Please ask for: Nicola Moore
Email: nicola.moore@arun.gov.uk
Telephone: Ext 37944
Our Ref: AW/230/20/HH
Your Ref:
Date: 17th September 2020

Application for Planning Permission for Works or Extension to a Dwelling

Development: Extended dropped kerb
Location: 17 Grosvenor Gardens Bognor Regis PO21 3EY

17 Grosvenor Gardens, Bognor Regis, PO21 3EY

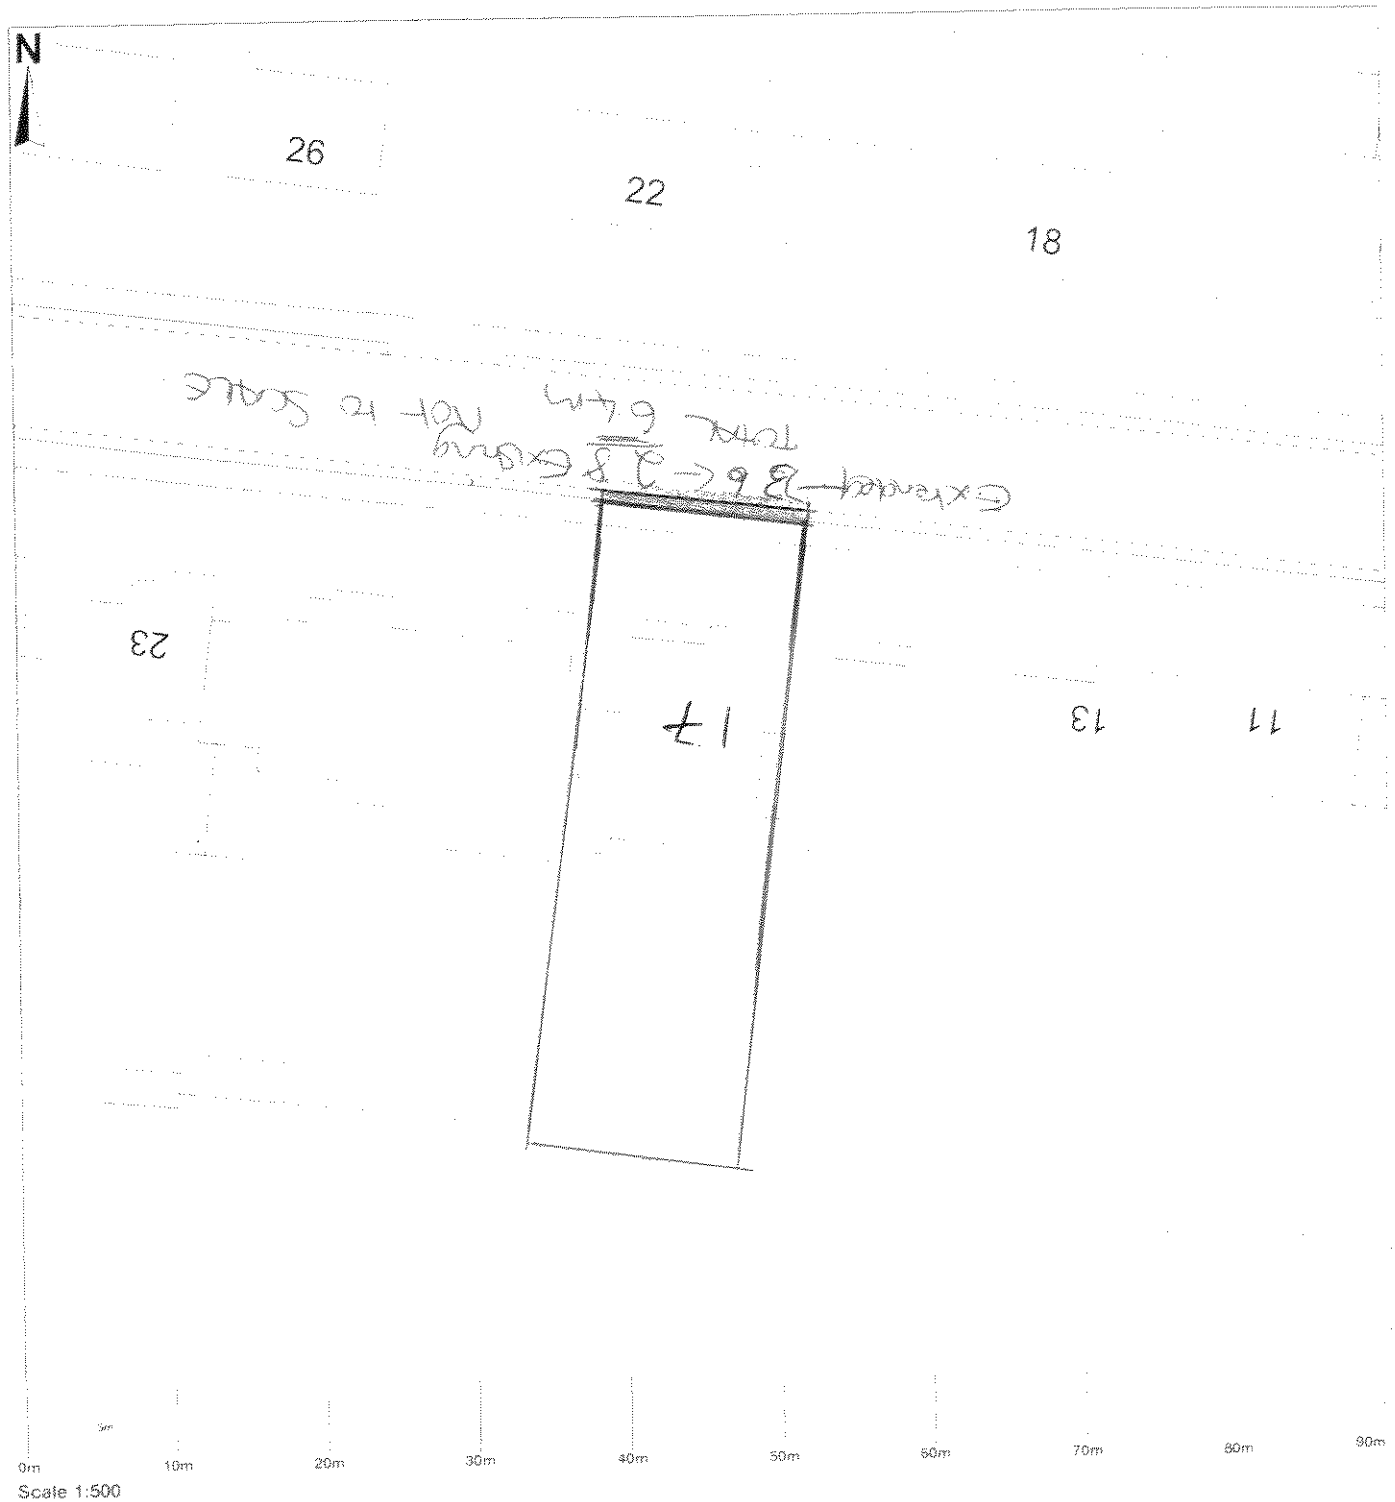
Block Plan

Please clearly edge the application site in red. Further details of what must be included on the plan can be found in the Validation Requirements List.
